Engineers Comments Regarding Surface Water Drainage

Application Reference:	AL/20/26/PL	Reviewer Reference:	ADC/EXT5/AF
Planning Officer:	Simon Davis	Date of Review:	23/04/2026
Site Name:	Land at West Barn Old Dairy Lane Norton PO20 3AF		
Application Description:	Demolition of existing tennis court and erection of a commercial building (within Use Class E(g), parking, landscaping and other associated works (resubmission following AL/107/25/PL). This application is a Departure from the Development Plan, may affect the character and appearance of the Norton Lane, Norton Conservation Area and is in CIL Zone 3 (Zero Rated) as other development.		
Assessment Number:	1

TYPICAL DETAILS OF SOAKAWAY USING
MODULAR UNITS

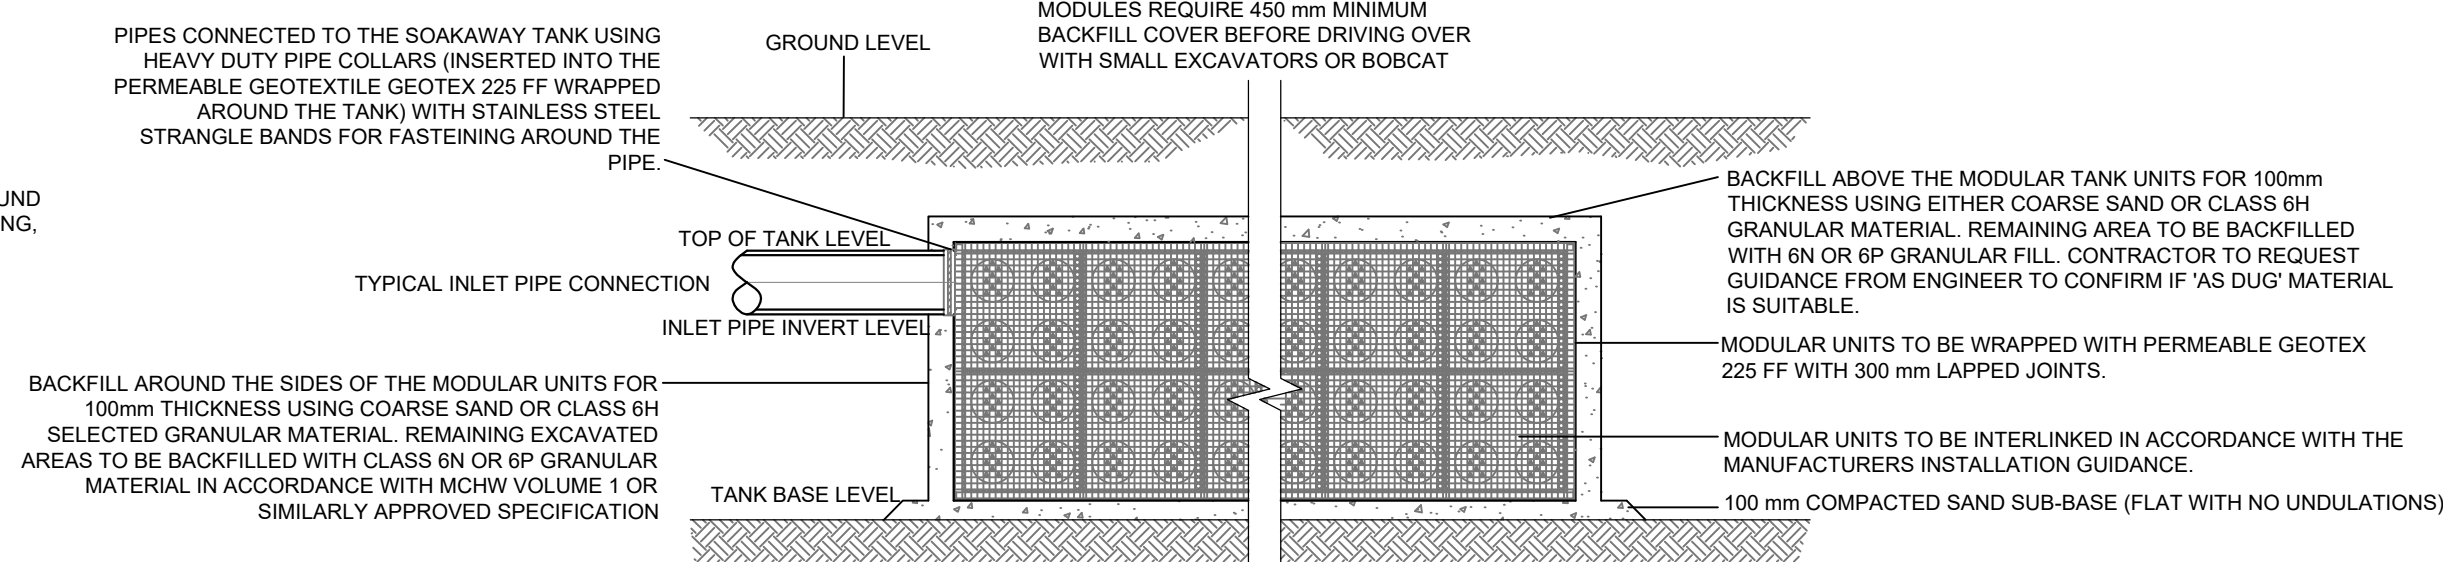
- 1.5. The highest groundwater level for the current data is 2.2m below ground level, this has not been converted to Ordnance Datum. The proposed soakaway is 1.1m deep. The base may therefore be

close to the 1m vertical offset and the annual peak has not been reached. Groundwater readings for February and to end March should be provided and converted to Ordnance datum to confirm that the soakaway is viable.

**PROPOSED DRAINAGE LAYOUT**  
SHEET 1 of 2

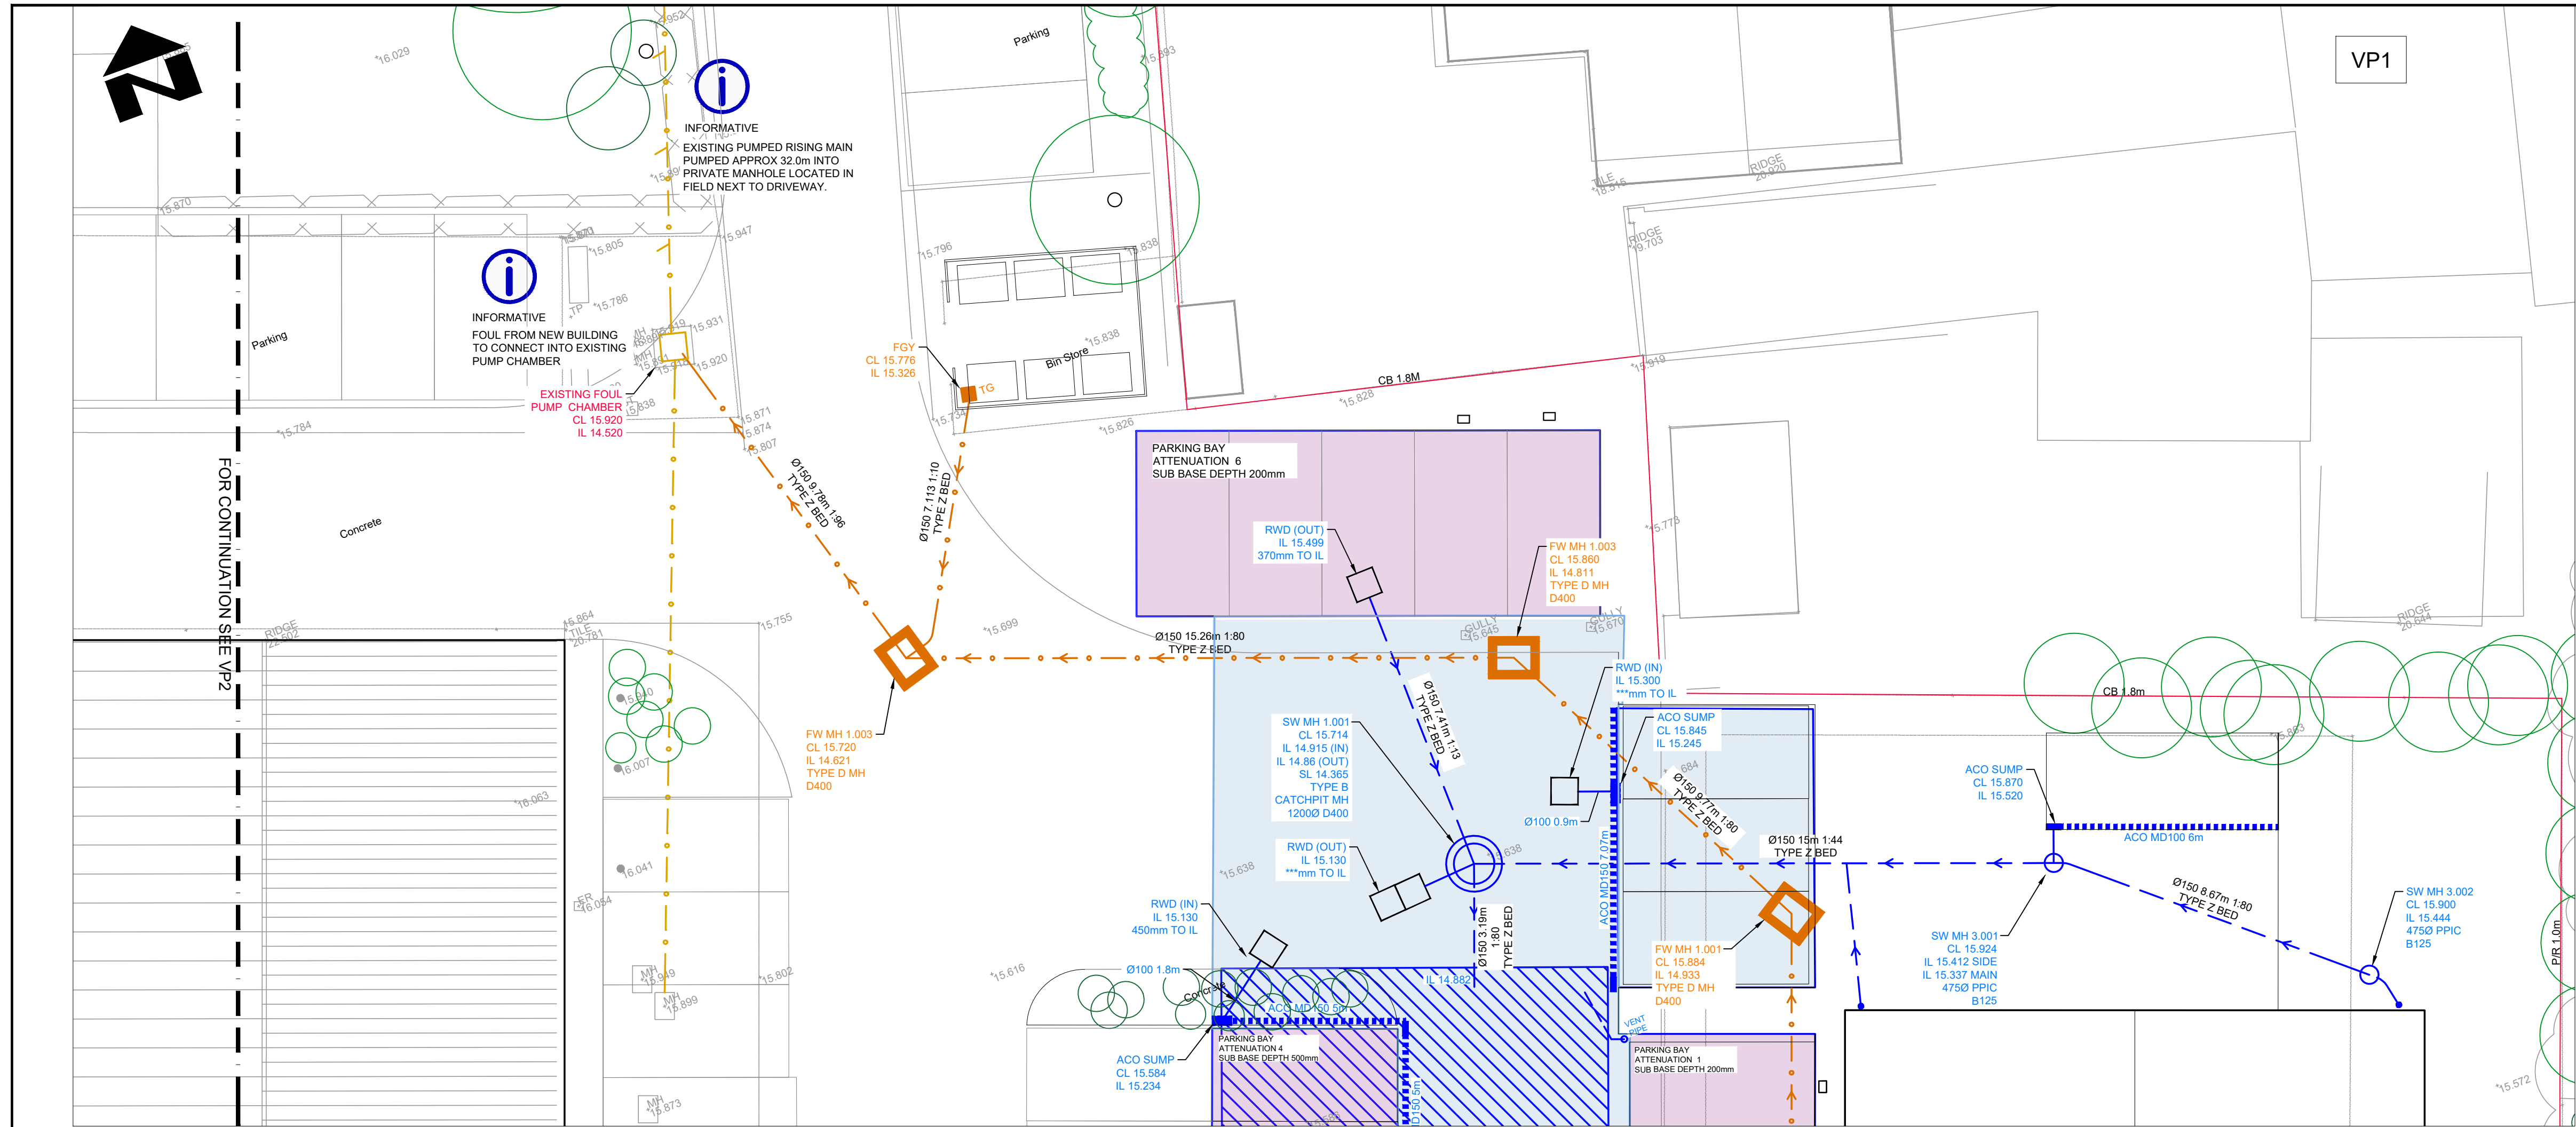
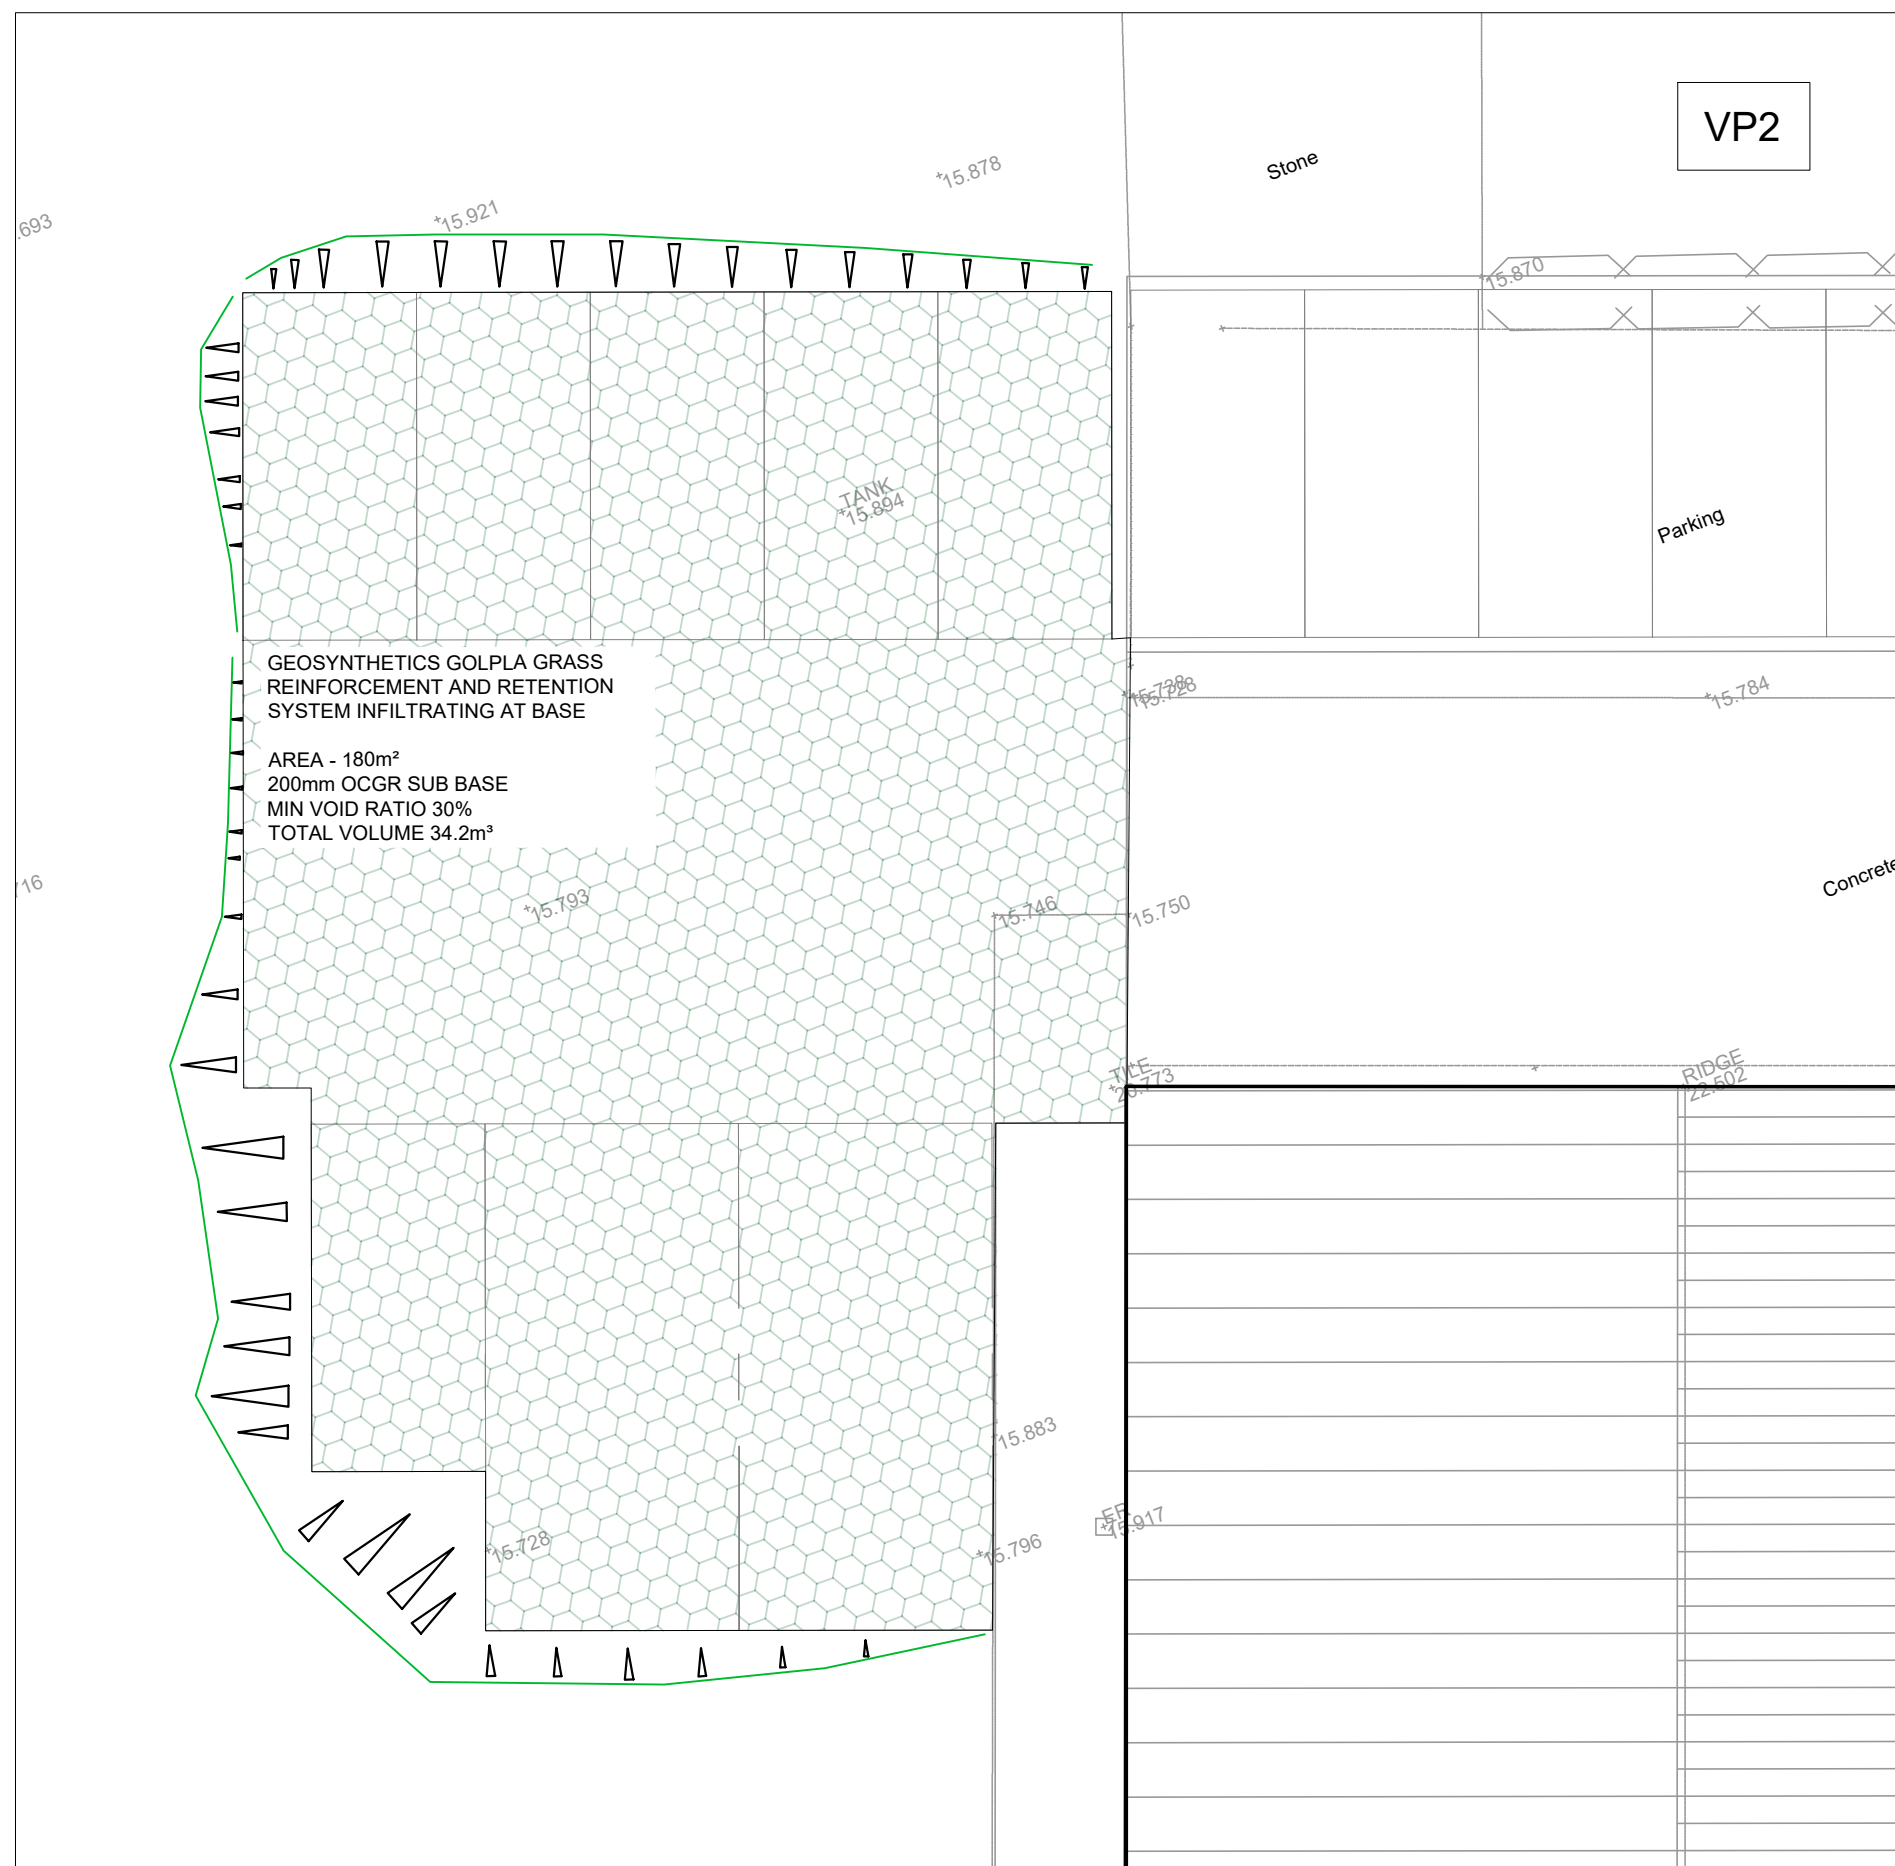
- 1.1. We concur that rainwater harvesting is not required at this development on the basis of limited demand for non-potable water.
- 1.2. The drainage strategy is to discharge to ground via a modular crate storage soakaway.

- 1.6. No alternative method of disposal is proposed should infiltration not be viable and the development is reliant upon the currently drainage strategy which must therefore be demonstrated to be viable at planning stage.
- 1.7. The design is not currently in accordance with the requirements of the NSfS (Standard 1). Therefore, we **object** to the application.

Chart 1 – Groundwater Records

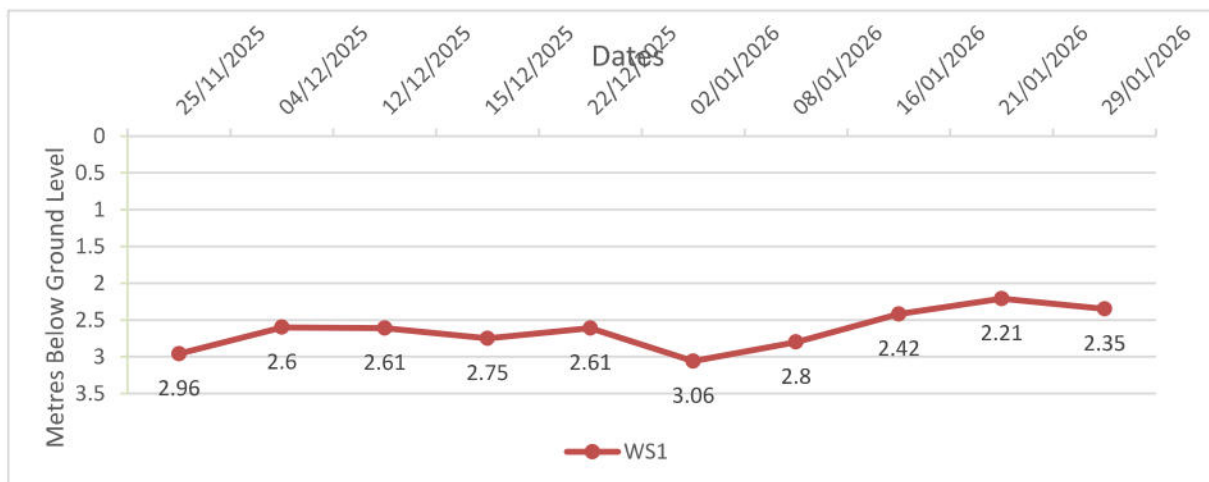
- 1.3. A ground investigation has been provided which includes winter groundwater monitoring up to the end of January 2026 and it is stated in the ground investigation report that groundwater levels are increasing up to a likely seasonal maximum in March. The current information on groundwater monitoring does not meet ADC requirements published on our webpages here:
<https://www.arun.gov.uk/groundwater-monitoring>.
